**Reviewed by:  
Glenn Reese, P.E.  
Stormwater Engineer I  
glennreese@elpasoco.com  
719-675-2654**

**SMALL SUBDIVISION FINAL DRAINAGE REPORT  
FOR  
CLOVERLEAF FILING NO. 1**

**December 1, 2020**

**Add text:  
PCD Filing No.: SF-21-014**

KEY MAP
SCALE: N.T.S.

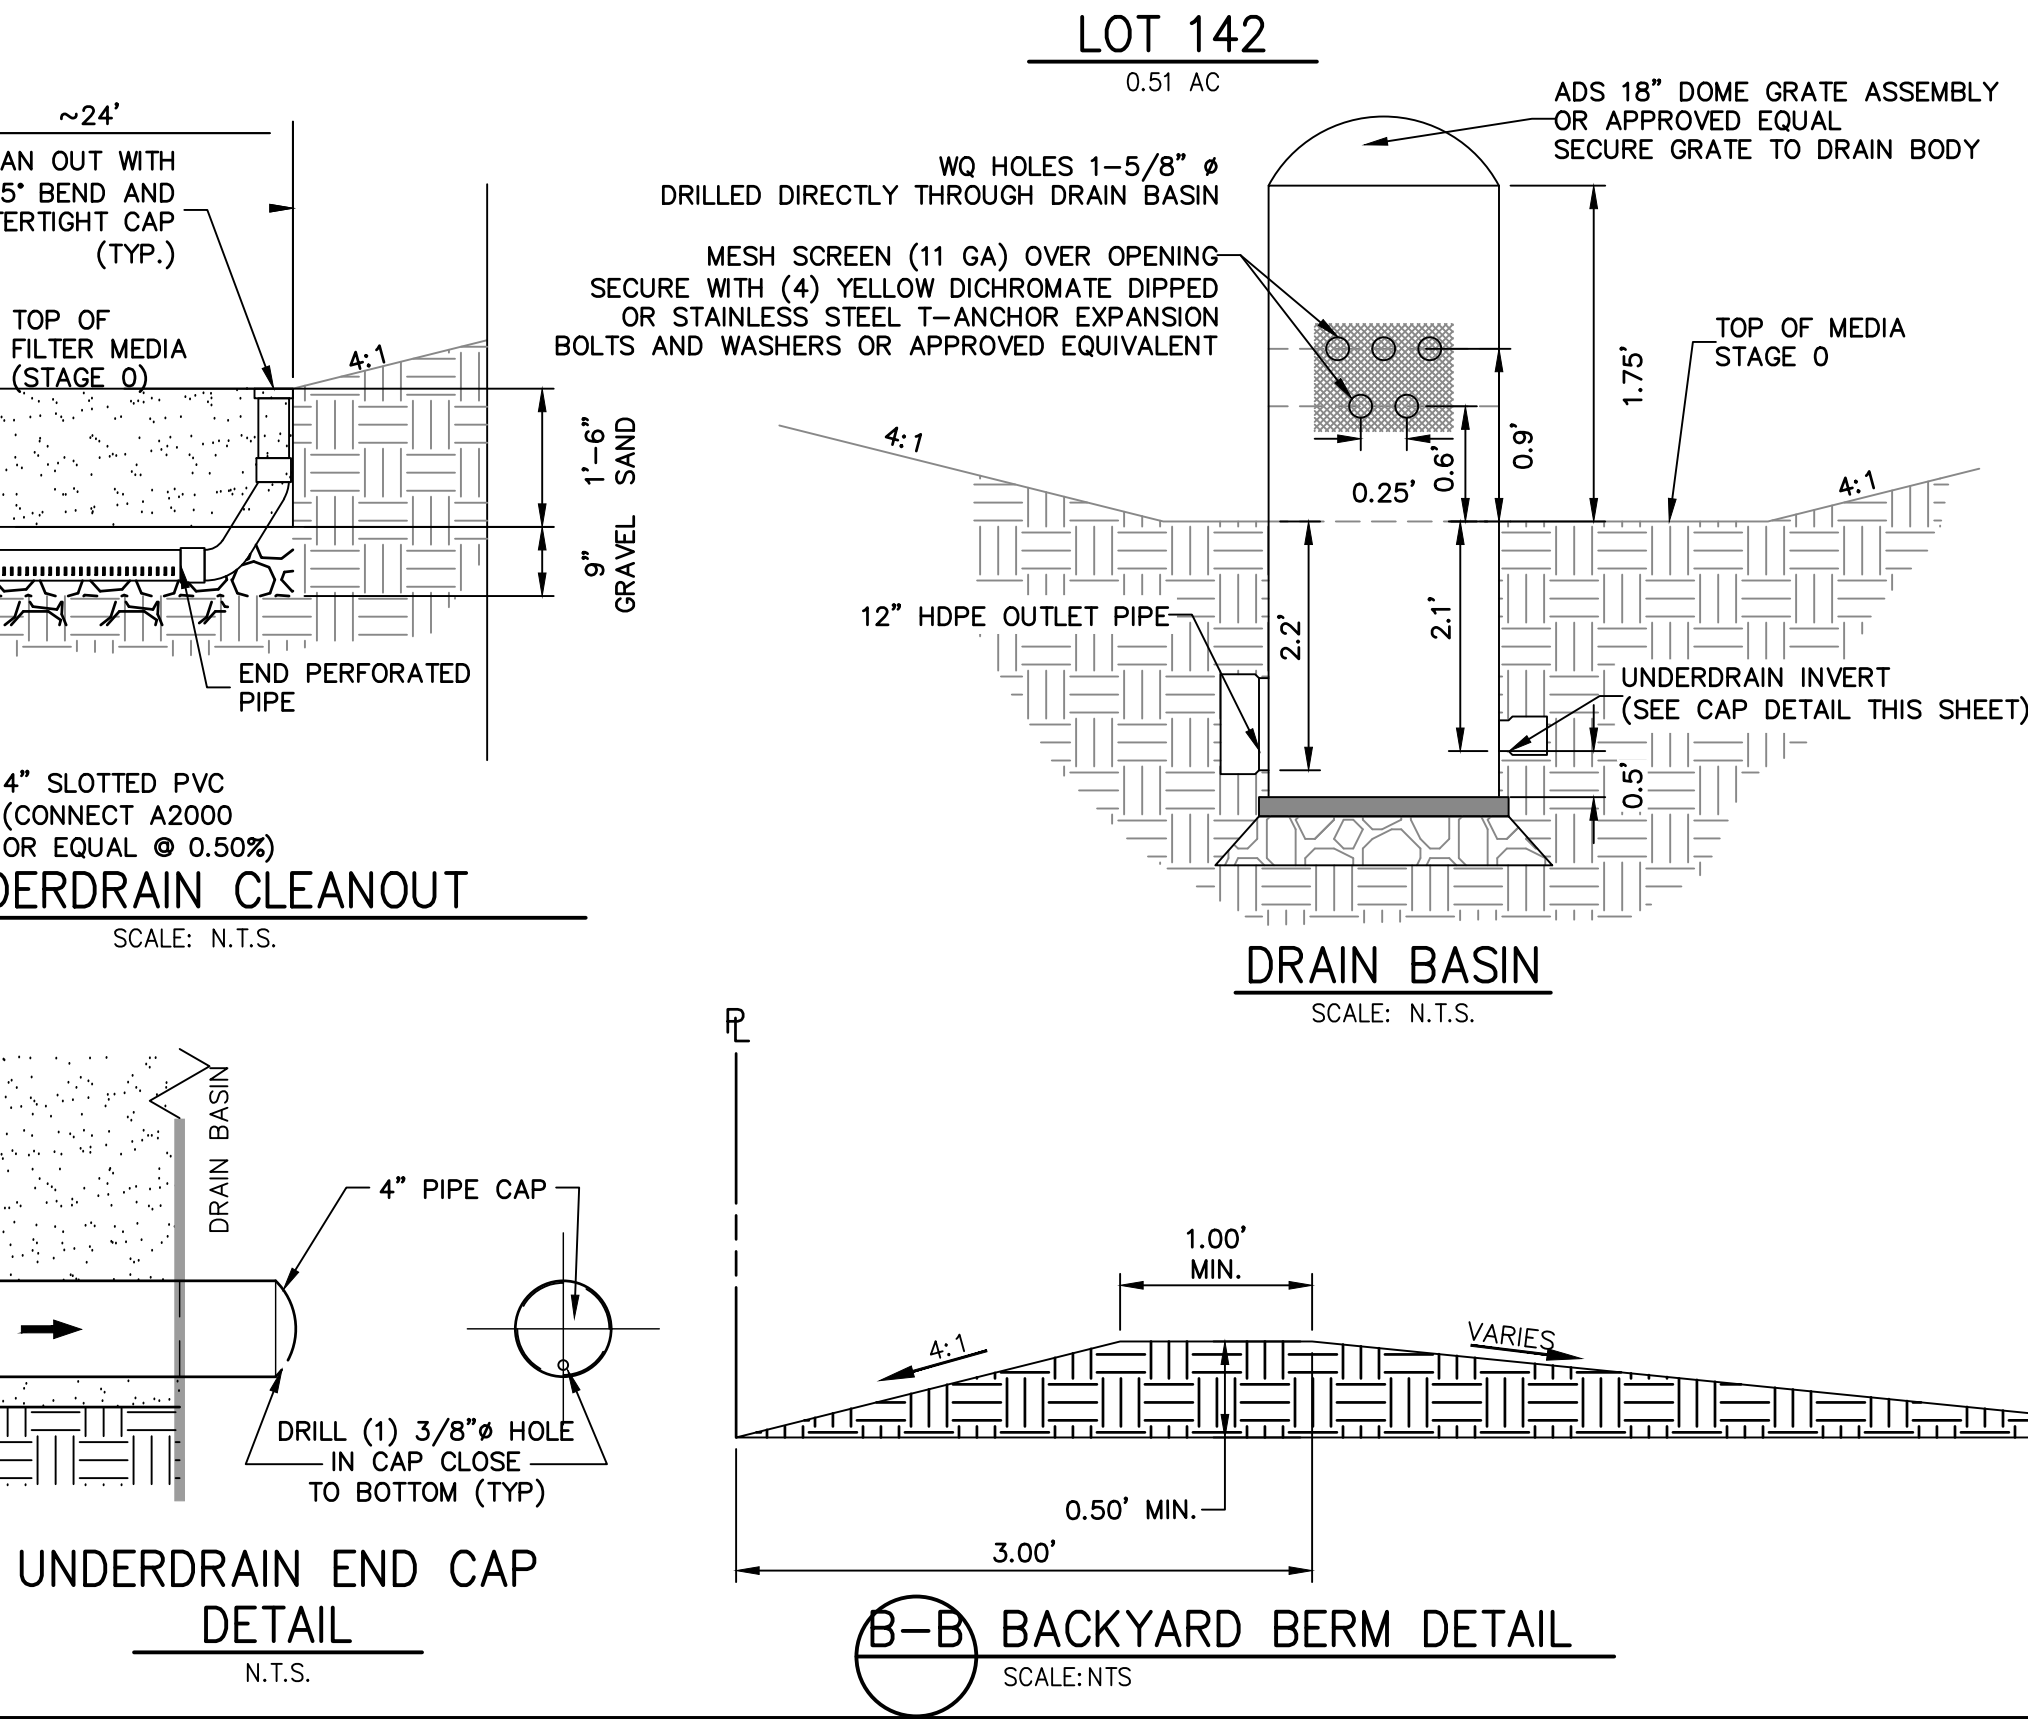
Please explain how. Is there a berm around the property to prevent offsite flow from entering the site? It looks like the land to the east of lots 143 and 144 flows onto these lots.  
If needed, include tributary basins into the rational method calcs in Appendix B
